CONDITIONAL USE PERMIT Kittitas County Board of Adjustment

A permit is hereby approved and issued to Washington State Department of Transportation (WSDOT) to conduct a temporary asphalt and concrete batch plant on the property described as being a site at the existing WSDOT quarry on the summit of North Umptanum Ridge located to the West of the North and South bound lanes of Sr 82, SE 1/4, Section 24, Township 15, Range 19, W.M., Kittitas County, Washington.

ANNUAL INSPECTION REPORT

PERMIT NO. 10054 MINE NAME: OS-S-234 INSPECTION DATE: 9/15/93
LOCATION: West of I-82 on Umtanum Ridge
SUBSEQUENT USE OF SITE: None listed, assumed to be marginal grazing

DISTRICT 5
RECLAMATION PLAN
QUARRY SITE QS-S-234

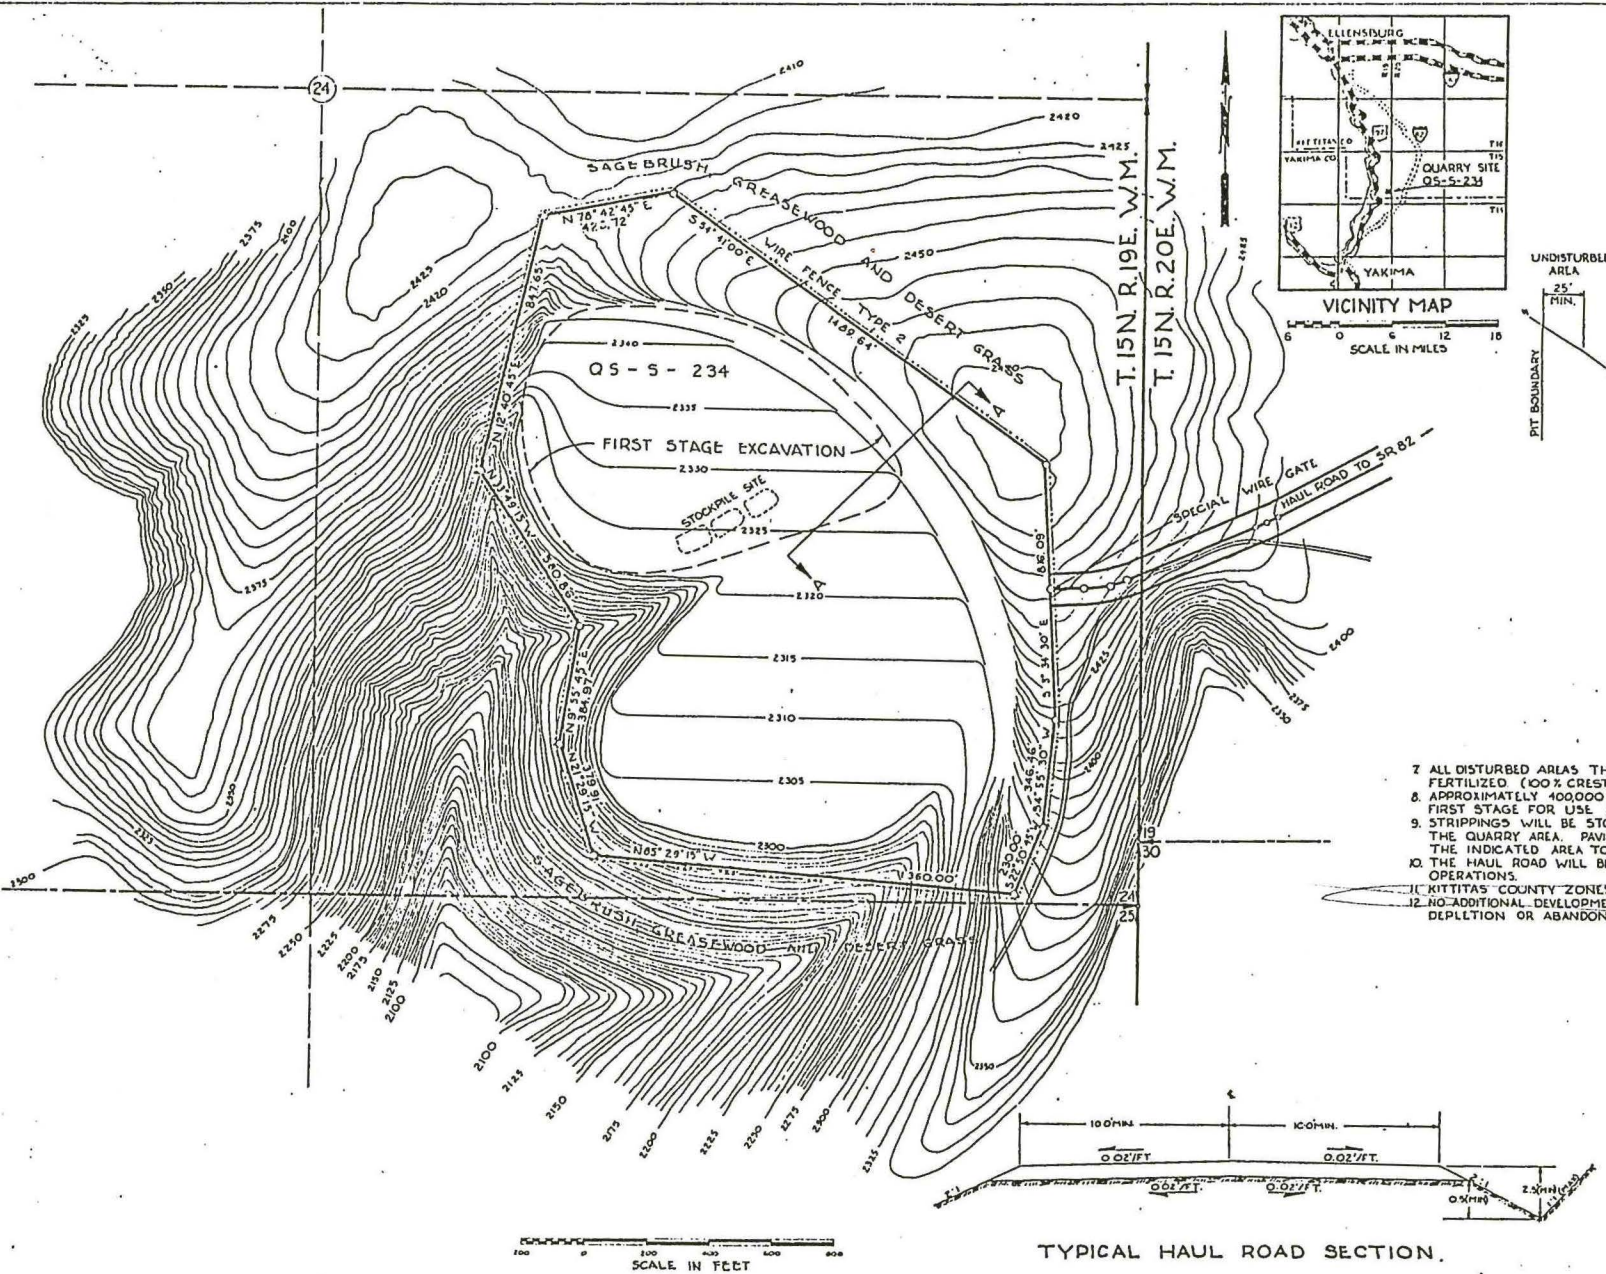
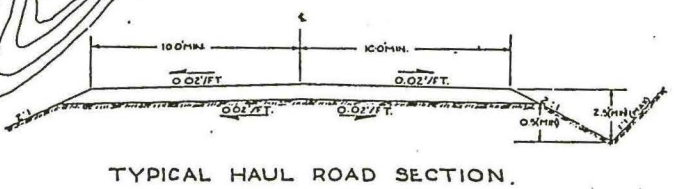
- a. This office does not have a copy of the SM-2 or SM-6 Forms for this site.
- b. If the quarry is enlarged, slopes should be in accordance with the 1993 Reclamation Law (i.e. between 2:1 and 3:1). The present slopes are close to that now.
- c. The quarry is presently slightly back sloped into the hill. This should be incorporated into the design of the project. Back sloping will hold run off which will catch sediments and retain moisture for vegetation and wildlife.
